**KIRKLEES METROPOLITAN COUNCIL
INVESTMENT & REGENERATION SERVICE**

DELEGATED DECISION TO DETERMINE PLANNING APPLICATIONS

Reference No:	2022/62/90303/W
Site Address:	260 , Keldregate, Deighton, Huddersfield, HD2 1LE
Description:	Erection of single storey side extension and external alterations
Recommending Officer:	Sam Jackman

Officer Report – 2022/90303

Drawing
ELEVATIONS AS PROPOSED
(SHEET 1 OF 2)

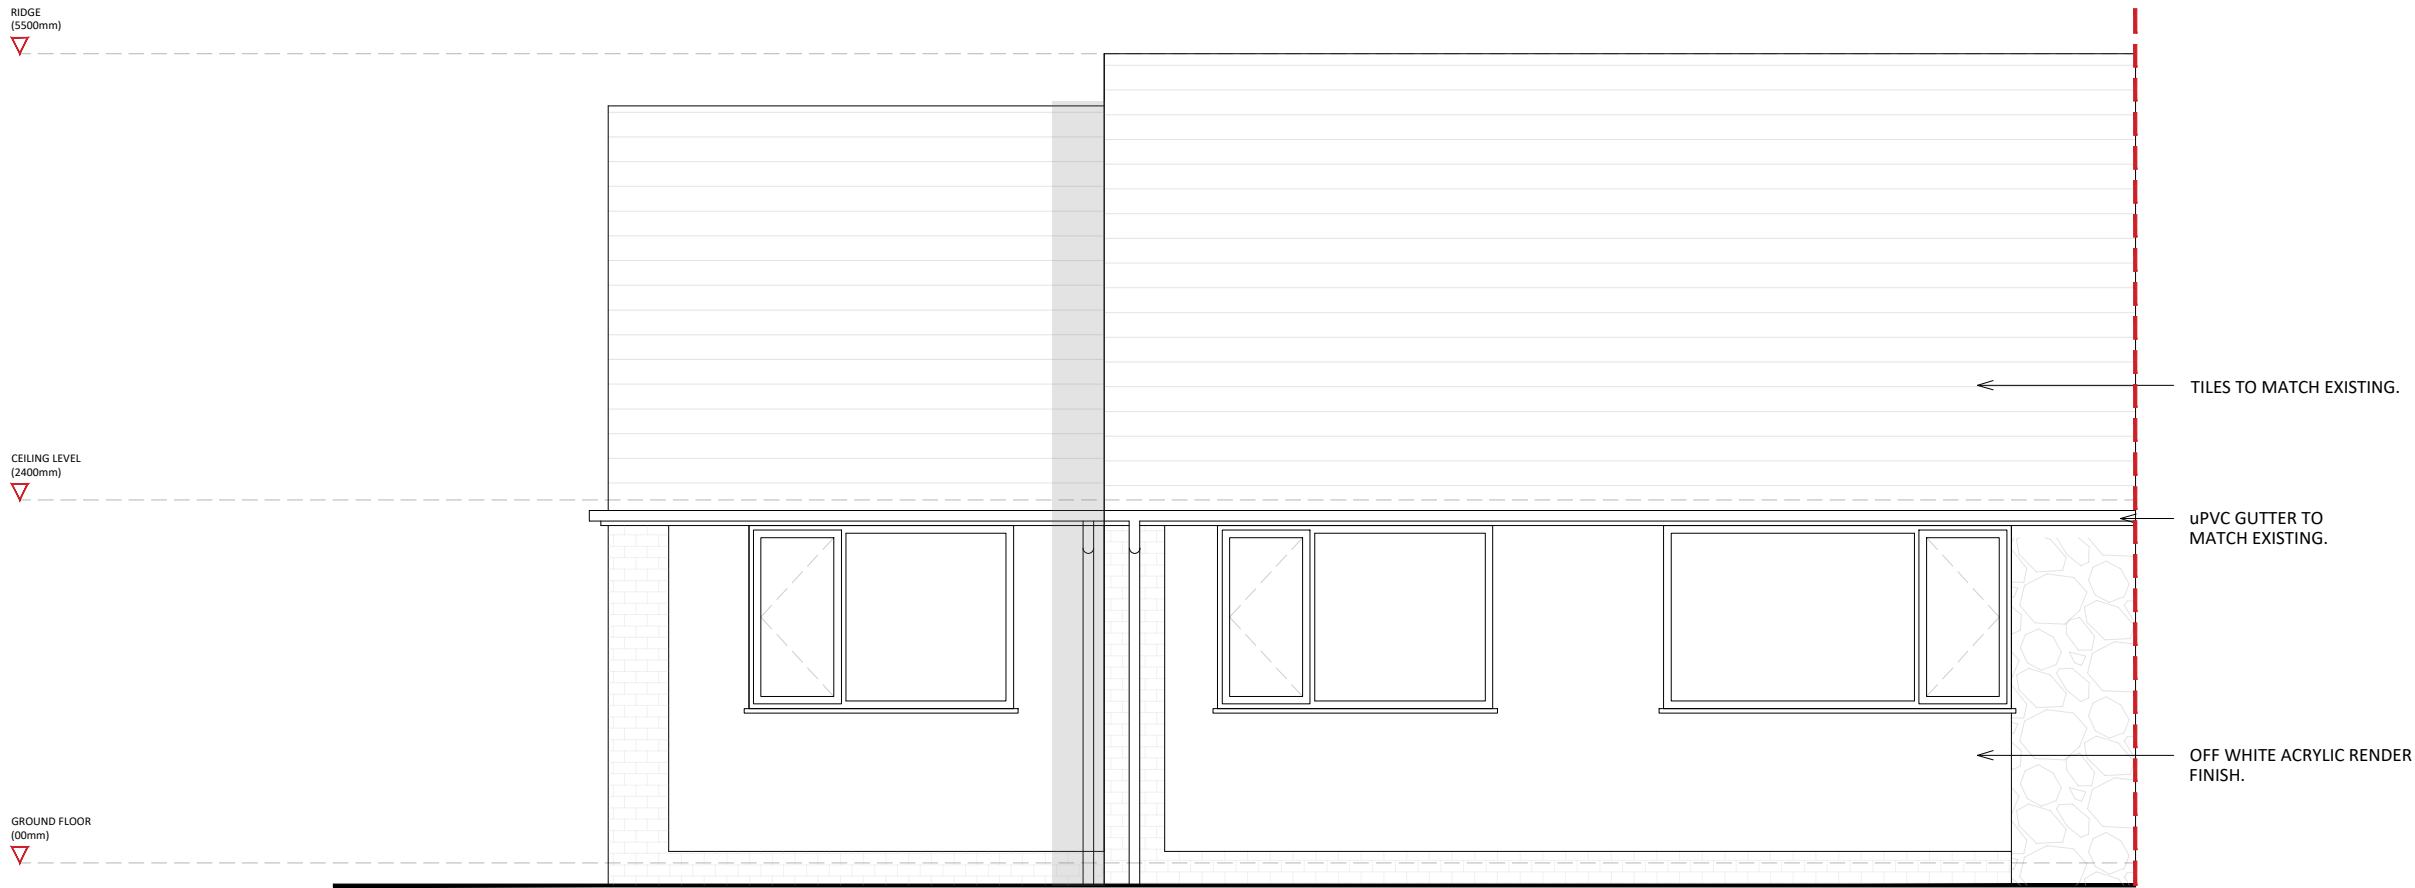
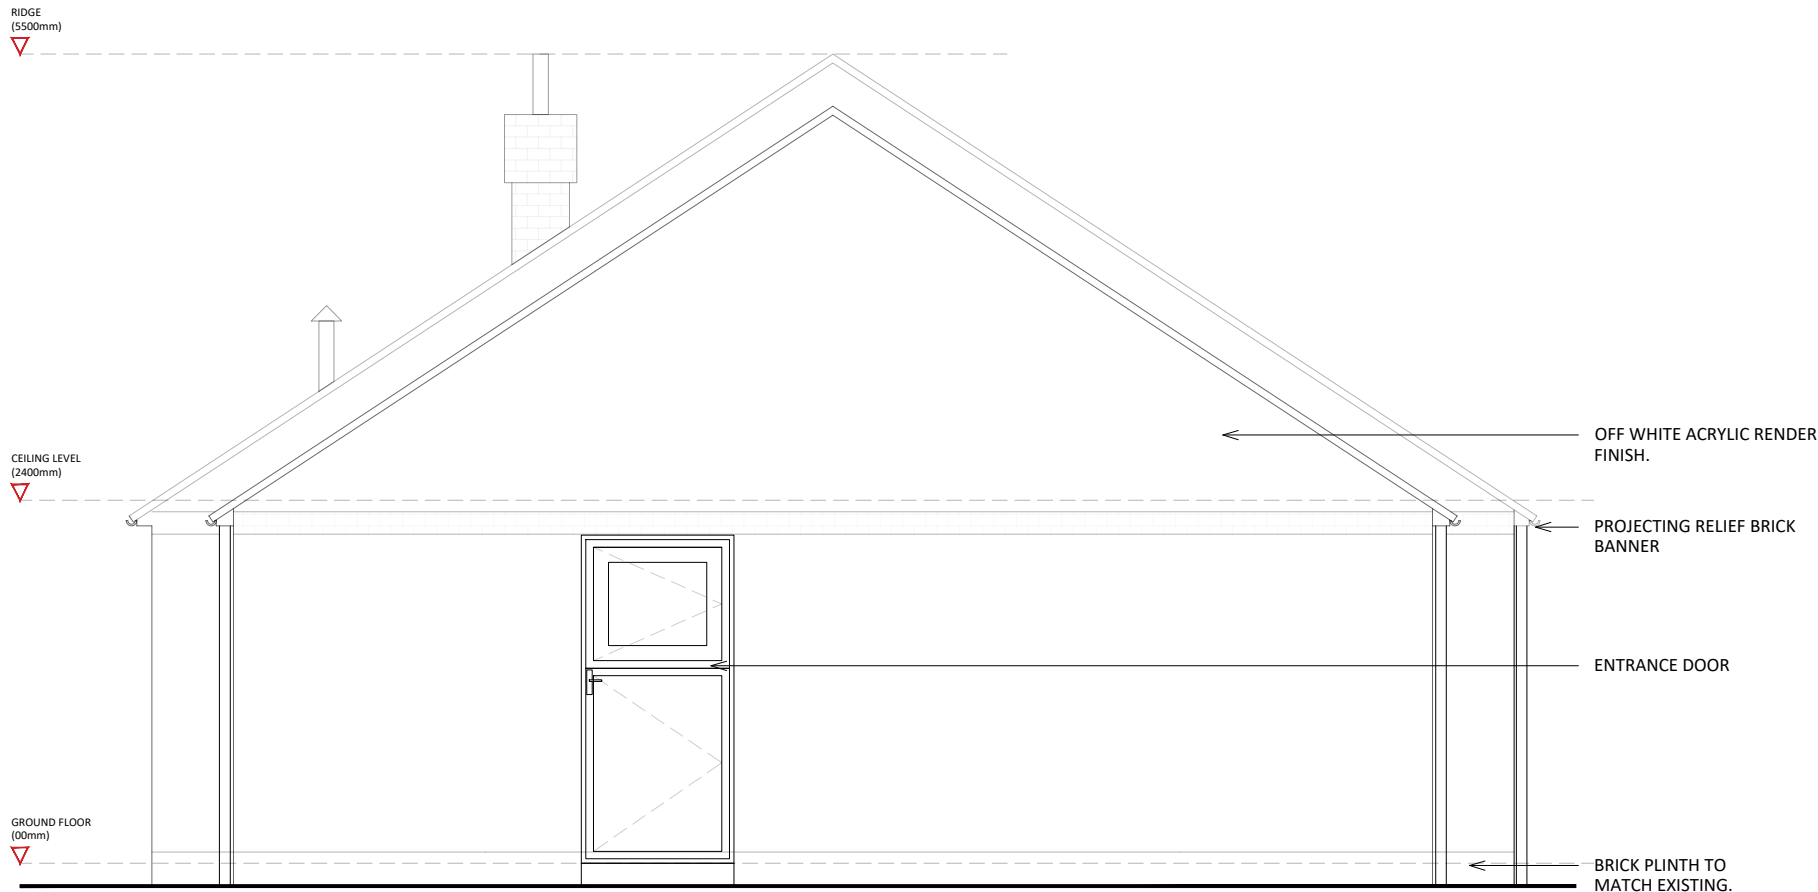
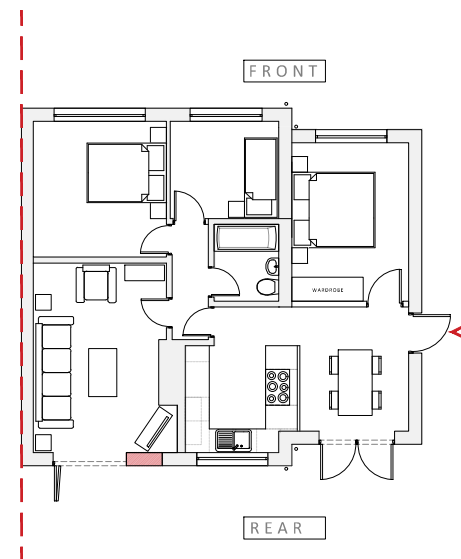
It is accepted that the side extension will be clearly visible from the north but less so from the south as it will be partially screened by the existing outbuilding. The extension would also be considered to be a front extension given the 2 road frontages and albeit it would project forward of the building line along Keldregate, it has a different relationship with the streets to that of its neighbours as it is seen to be part of Crawthorne Crescent and that the extension is to the side which currently is a blank elevation with only a central door. This detail will be reflected in the proposal albeit the SPD suggests the extension should have features to represent a front elevation. It is acknowledged that the extension would project beyond the 'building line' of Keldregate but in this isolated case, given the presence of the large garage and outbuildings there would be no material harm to the visual character of Keldregate from the erection of this now modest extension.

The design of the proposal is such that the side extension would have the eaves height to match the existing eaves and a roof line which is set down from the existing. The gabled roof design would be retained within the design of the side extension. This element of the proposal would broadly comply with the House Extensions and Alterations SPD with the plans indicating that the extension would be set in from the boundary with Keldregate by almost 4metres. This ensures a level of separation between the site and the roadside. Amended plans were sought to reduce the size of the side extension considerably, including the set in from both the front and rear elevations, of the property which has now been achieved and complies with the requirement of the SPD under subparagraph 5.20.

Drawing
PROPOSED FENCE DRAWING

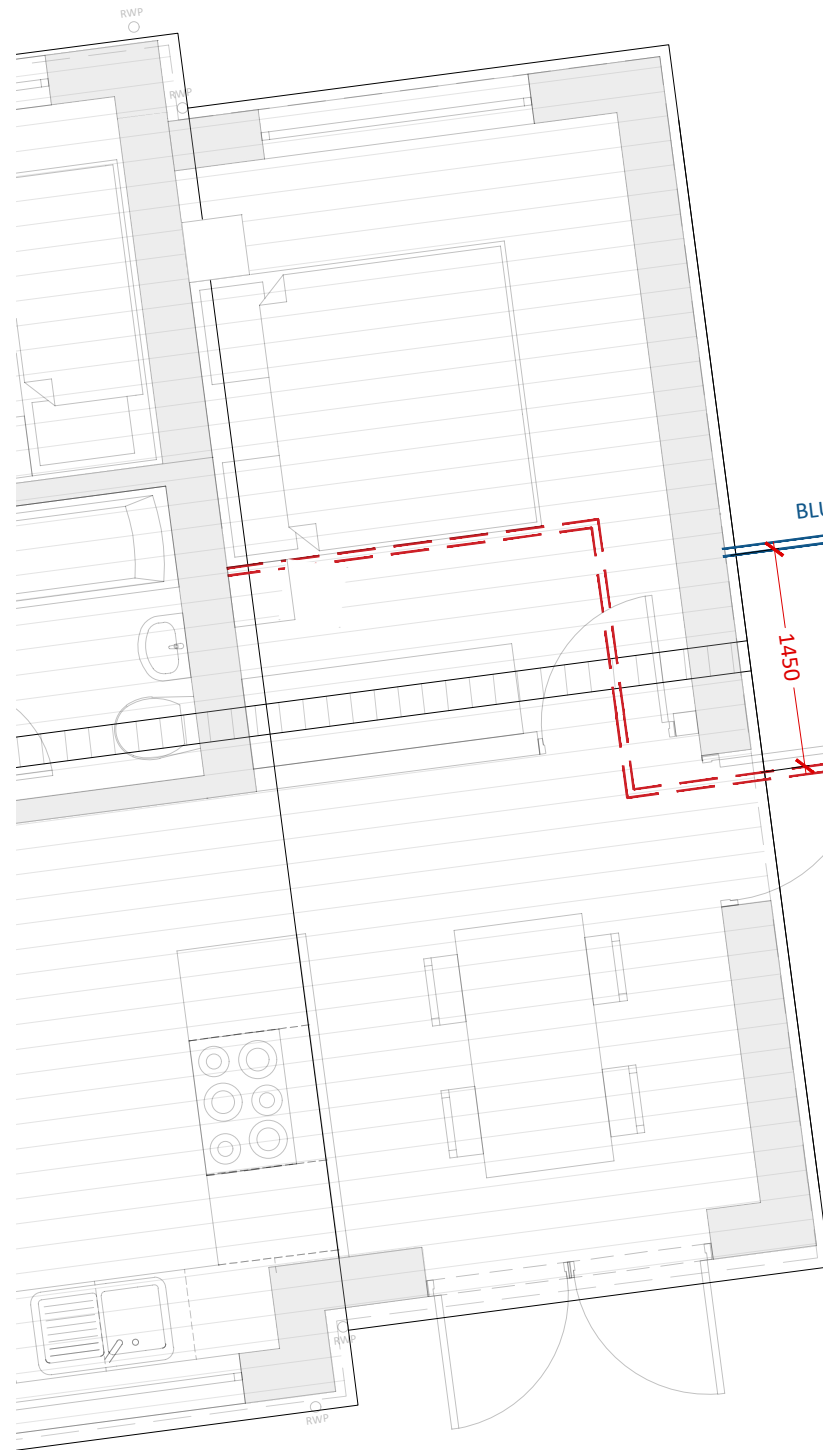
The proposed plan shows the new fence relocated 1.4m to the right of the new entrance retaining the enclosed rear garden.
